COMMENT OF SEPA THRESHOLD DETERMINATION

Kittitas PUD #1 Headquarters SE-26-00003

Subject Parcel: #051833 4271 Kittitas Hwy, Ellensburg, WA

Applicant: Manastash Architecture Planning and Development (MAPD)

C1.0

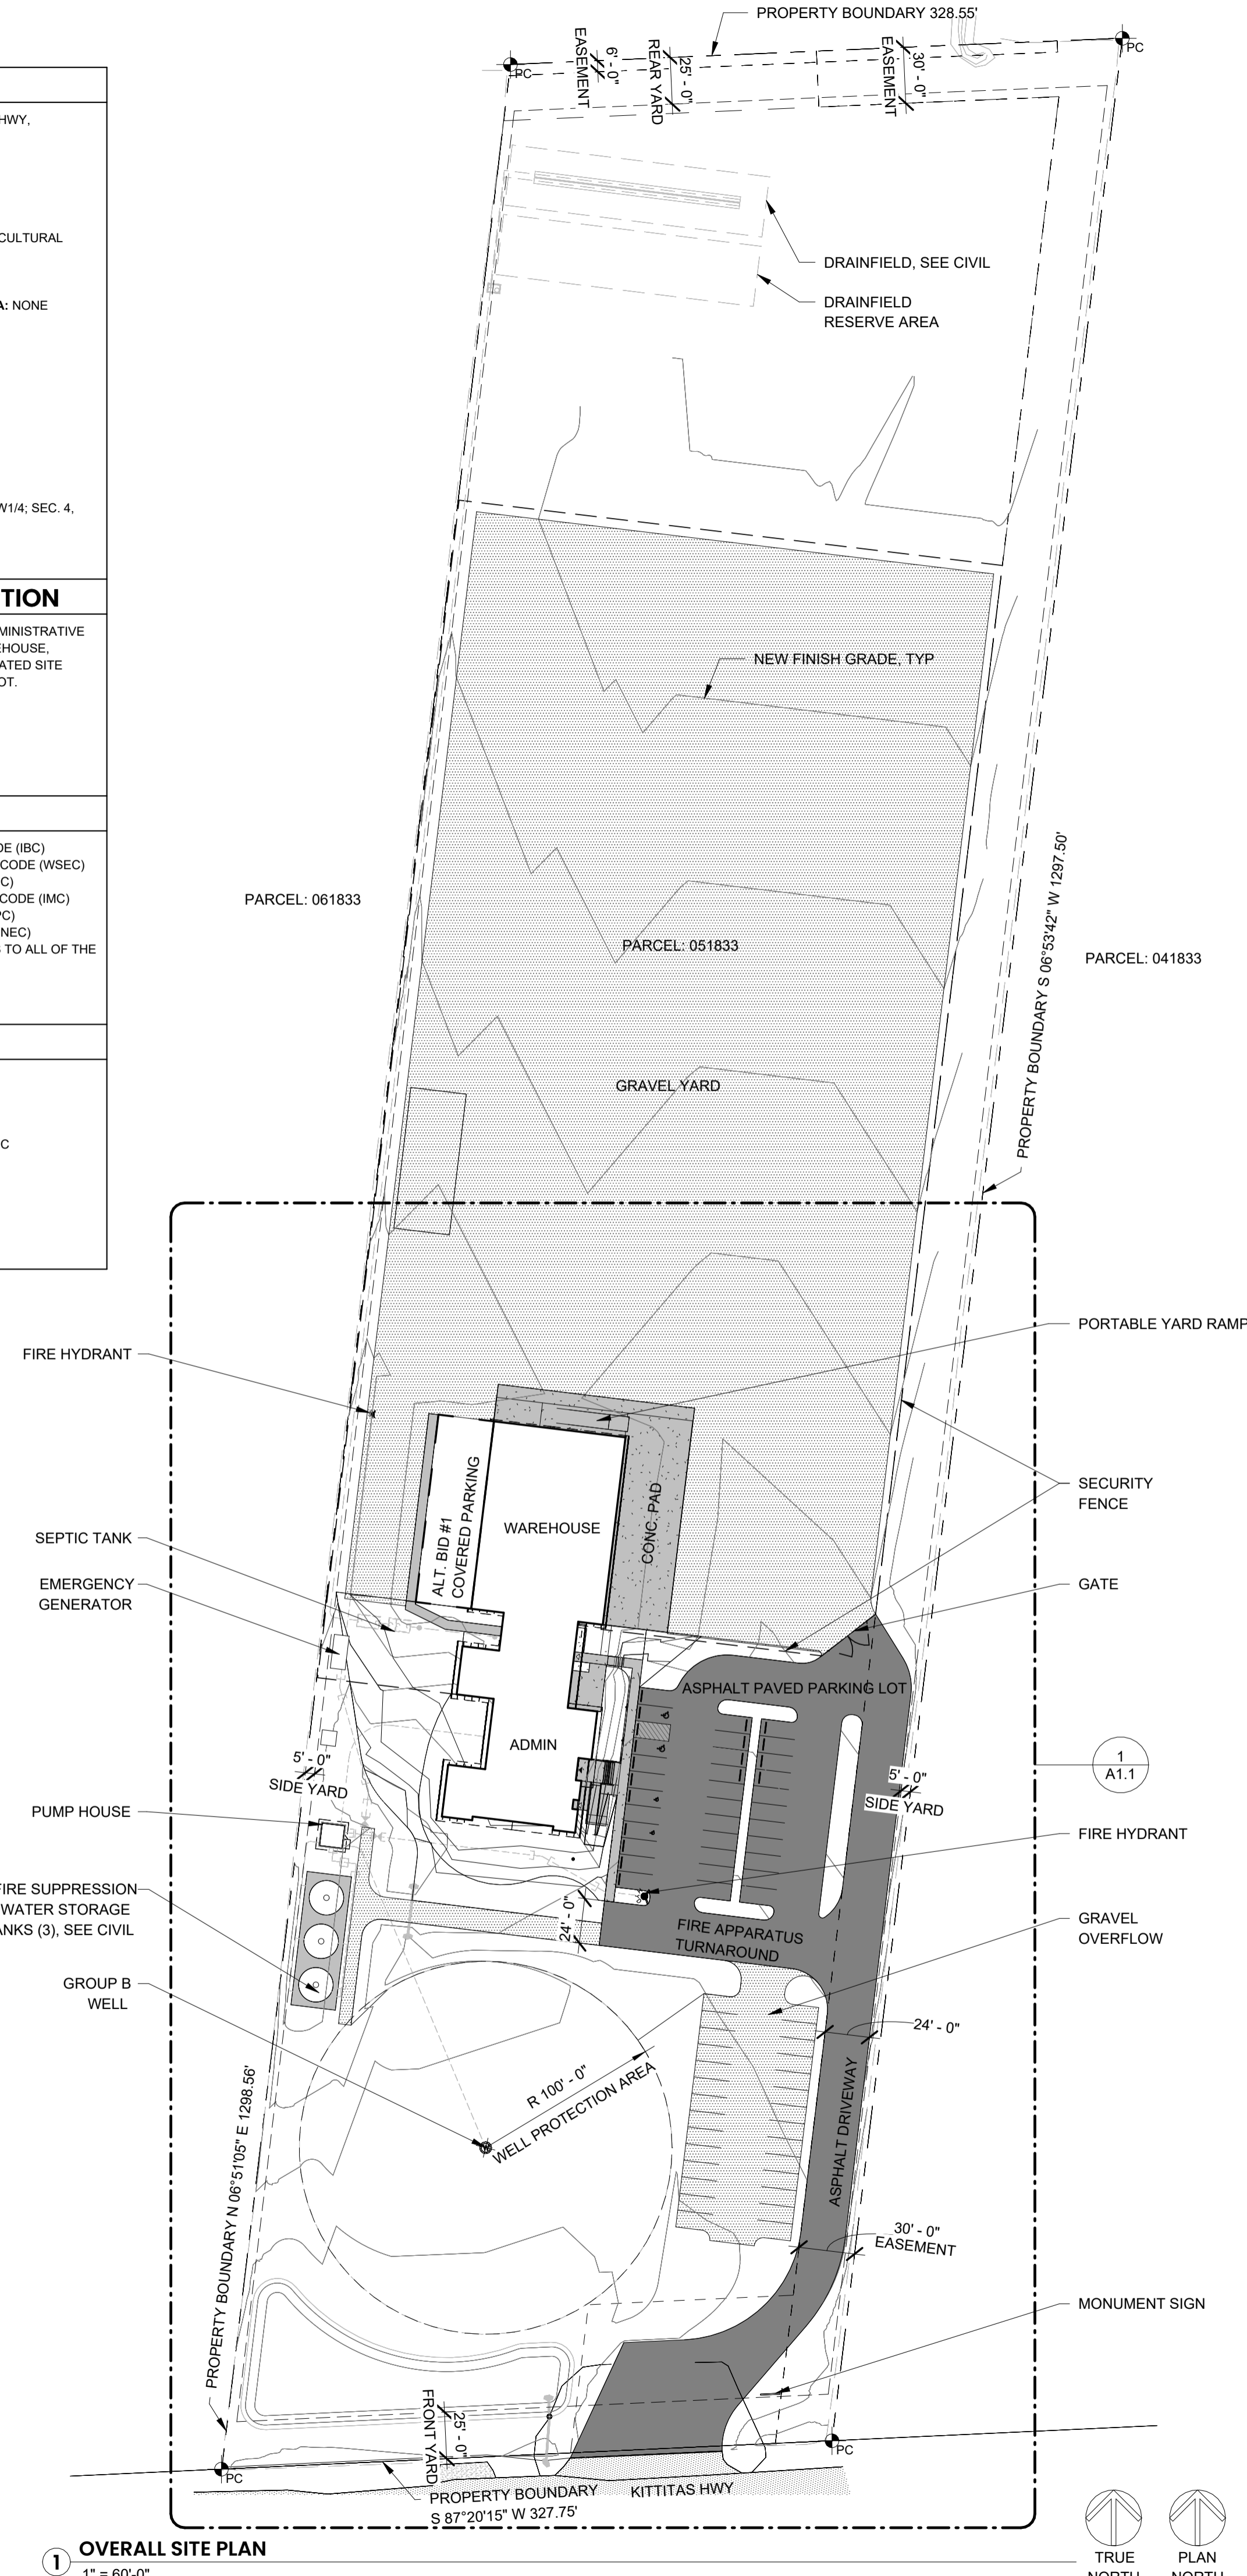
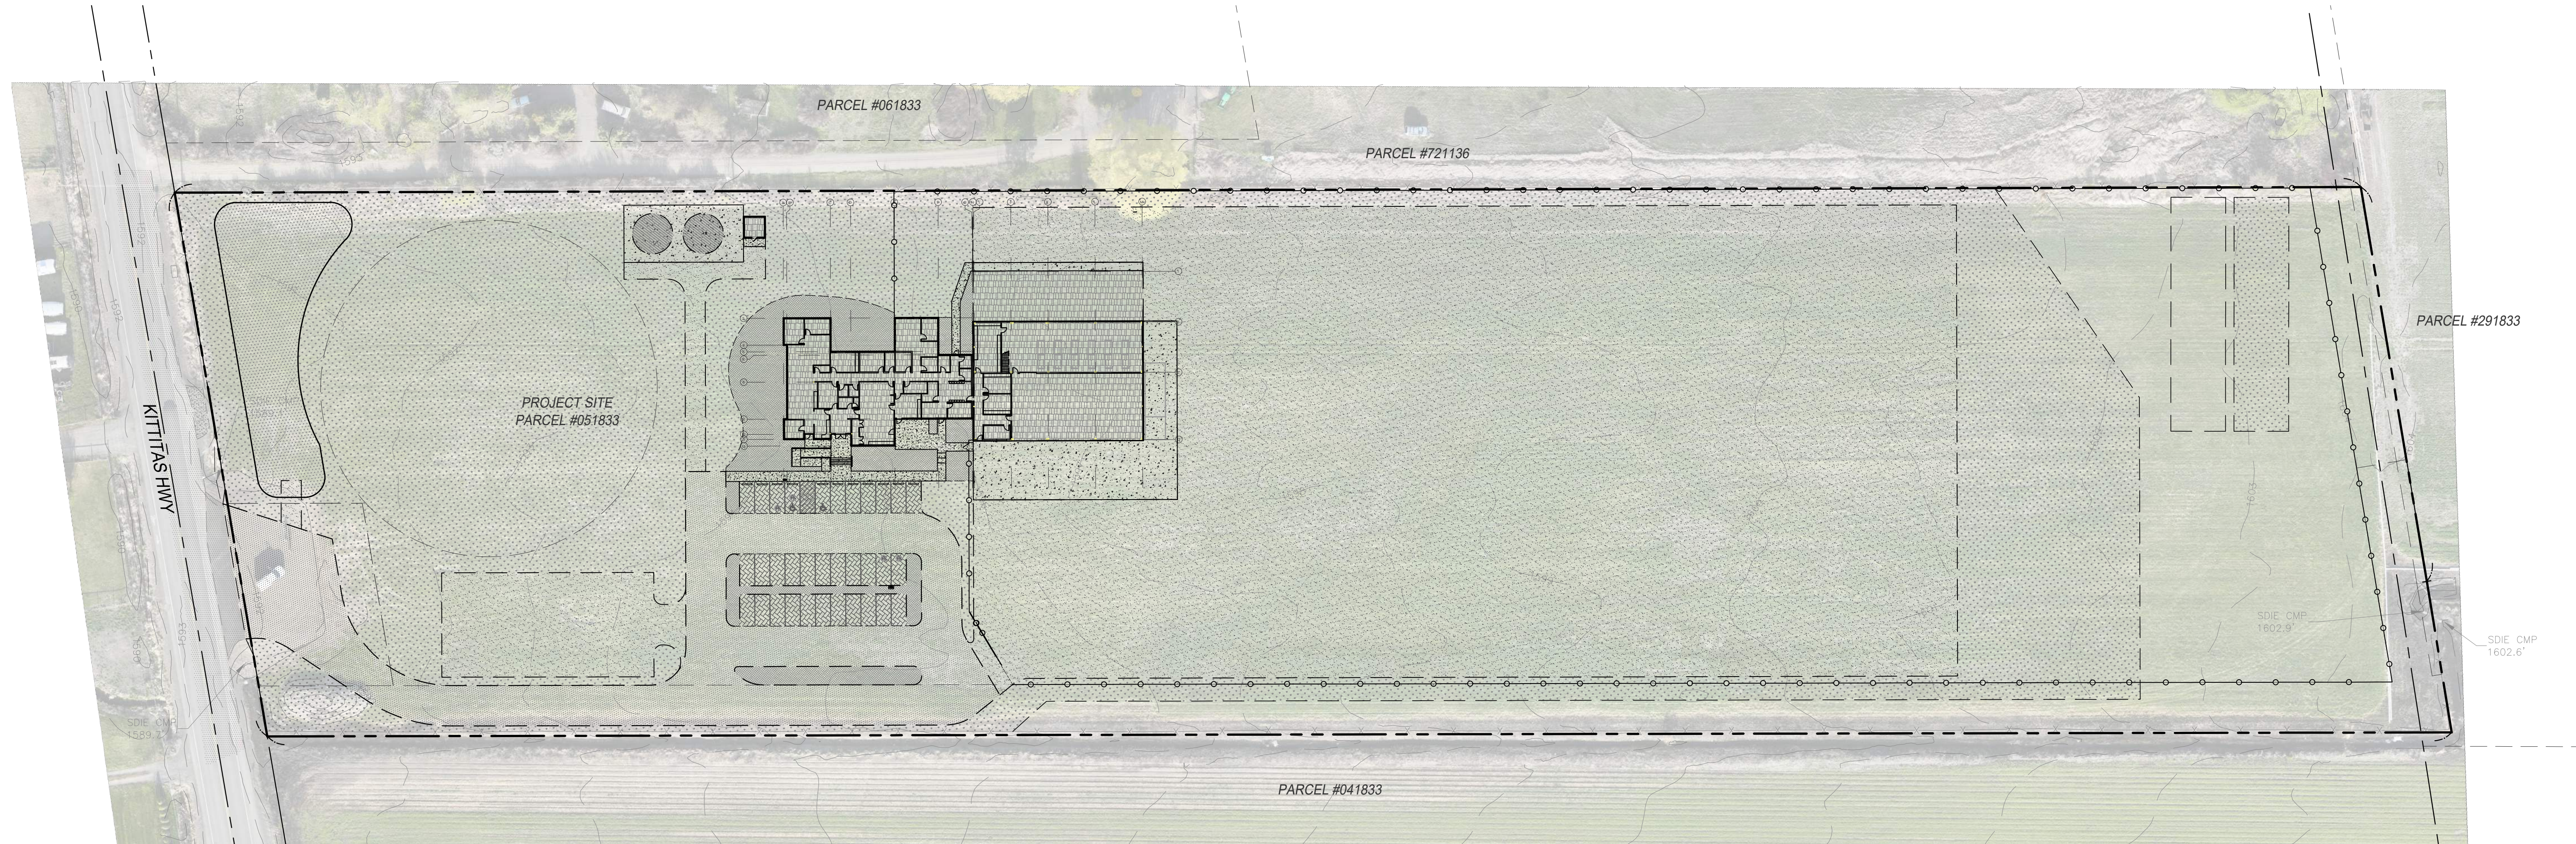
Checklist §B.7.a(3) states “no anticipated hazardous chemicals will be stored, used, or produced.” The site plan (Exhibit E) confirms three 60,000-gallon fire suppression tanks—180,000 gallons of dedicated fire water. Under NFPA 22, tank capacity must “reflect actual fire demand.” That volume is consistent with a facility storing transformer mineral oil (a Class IIIB combustible liquid), diesel fuel, hydraulic fluids, and potentially PCB-containing equipment—not a low-impact administrative office. The Group B well at 275 gpd would take approximately 655 days to fill the three tanks; the water source for the fire system is not disclosed. Analyzed in Section VIII. Controlling authority: Norway Hill Preservation & Protection Ass’n v. King County Council, 87 Wn.2d 267 (1976) (hard-look standard); Ellensburg Cement Products, Inc. v. Kittitas County, 179 Wn.2d 737 (2014) (DNS reversed for industrial use on A-20 in this same County).

Checklist §B.8.b and §B.14 contain no analysis of impacts to adjacent active agriculture. The site plan narrows Farmer Stakeholder’s 30-foot easement to a 25-foot paved strip, pinches the northeast corner with a rigid fence, and ignores an adjacent irrigation ditch that RCW 7.48.310(1) expressly identifies as part of a protected agricultural activity. Analyzed in Section V. Controlling authorities: *Zonnebloem, LLC v. Blue Bay Holdings, LLC*, 200 Wn. App. 178, 184 (2017) (“actions that make it more difficult to use an easement . . . are prohibited . . . unless justified by the needs of the servient estate”); *Buchanan v. Simplot Feeders Ltd.*, 134 Wn.2d 673, 680 (1998) (Right to Farm three-part test); *Thompson v. Smith*, 59 Wn.2d 397, 408–09 (1962) (easement balancing test).

The site plan (Exhibit E) allocates zero acres of the 9.65-acre parcel to designed greenspace, landscape buffers, working agriculture, or native vegetation. The dominant land use is a 5.79-acre industrial gravel yard (60% of the parcel) with no visual screening between the PUD operation and Farmer Stakeholder’s adjacent active hayfield, no street-frontage landscaping along Kittitas Highway, and no internal vegetation of any kind. The 30-foot agricultural easement along the eastern boundary is encumbered land within the PUD parcel that cannot be counted as project greenspace under any methodology. By contrast, a typical single-family residence on a comparable 10-acre rural parcel in Kittitas County leaves 80–90 percent of the ground in a combination of pasture, hay, garden, ornamental landscape, trees, and native vegetation—the configuration the County’s comprehensive plan designates as “Rural Working.” A site plan with zero greenspace cannot satisfy the comprehensive plan’s “Rural Working” designation, the GMA’s open-space and natural-resource goals at RCW 36.70A.020(8)–(10), or the KCC 17.60A conditional-use compatibility requirement that mitigation include “landscape buffers, special setbacks, screening, and/or site design using physical features.” Analyzed in Section V.L. Controlling authorities: WAC 197-11-444 (land use, plants, animals, aesthetics, and recreation as enumerated elements of the environment); RCW 36.70A.020 (GMA planning goals); KCC 17.60A (conditional-use compatibility findings).

Exhibit E (Overall Site Plan A1.0 / C1.0) shows a 6,300 sf administration building, a 10,200 sf pre-engineered materials warehouse, a large fenced equipment and materials yard, two (or three) 60,000-gallon fire suppression water tanks, an emergency generator, a Group B well and pump house, a septic tank with drainfield and reserve area at the north end, a portable yard ramp, and approximately 53.5% total impervious coverage. The project narrative and public notice nevertheless frame the proposal as a low-impact "administrative facility."

Farmer Stakeholder's adjacent parcel contains a known chronically wet area at the terminus of the shared 30-foot easement. Exhibit E locates the primary drainfield and drainfield reserve area at the extreme north end of the subject parcel directly adjacent to this wet zone. Exhibit F (Critical Areas) shows a PSS1A palustrine scrub-shrub wetland and mapped hydrologic features in the immediate vicinity. No hydrogeologic analysis, effluent migration analysis, or seasonal saturation study has been provided.

Exhibit E depicts the PUD’s paved access and circulation surface within the 30-foot easement as approximately 25 feet wide, with a perimeter security fence running alongside the paved strip on the PUD side. Five feet of the recorded 30-foot easement is thereby converted from usable agricultural travel width to an unpaved shoulder pinched between the fence and the paved edge. For a haying operation, that five-foot reduction is not cosmetic: modern haying equipment routinely exceeds 12 feet in transport width, and oversized loads such as stacked bale wagons commonly require the full width of a 30-foot easement plus overhang tolerance to navigate without damage. The checklist does not disclose the actual paved width, the fence setback, the effective functional clearance, or any analysis of whether common haying equipment can operate within it.

Exhibit E shows that the PUD parcel comes to a sharp corner at its northeast boundary along the line where the easement and Farmer Stakeholder's field meet. Agricultural equipment making the turn into or out of the field at that corner routinely overhangs the fence line. A rigid perimeter security fence at that corner, installed tight to the pavement edge, converts overhang tolerance into a hard stop: any implement that extends beyond the tractor profile will strike the fence. In practical terms, the sharp-corner geometry plus a rigid fence on the PUD side closes the turn for any equipment larger than a light tractor. No turning-movement analysis, equipment clearance envelope, or fence placement analysis appears in the SEPA record.

An irrigation ditch runs along the east side of the easement corridor and is part of the water conveyance system serving the surrounding fields. Irrigation ditches in the Kittitas Valley are active, pressurized or gravity-fed infrastructure, and disturbance, sedimentation, or contamination at any point can propagate through the network. The SEPA record does not identify the ditch at all, does not describe any separation between the proposed paved surface and the top-of-bank, does not address whether construction activity will cross or realign the ditch, does not explain where stormwater from the paved PUD access will go, and does not discuss the operational consequences of discharging paved-surface runoff into an active agricultural irrigation ditch. Runoff directed into that ditch, intentionally or otherwise, would deliver petroleum residues, transformer-related compounds, de-icing materials, and herbicide residues to downstream farms, implicating RCW 90.48.020 and the Water Pollution Control Act.
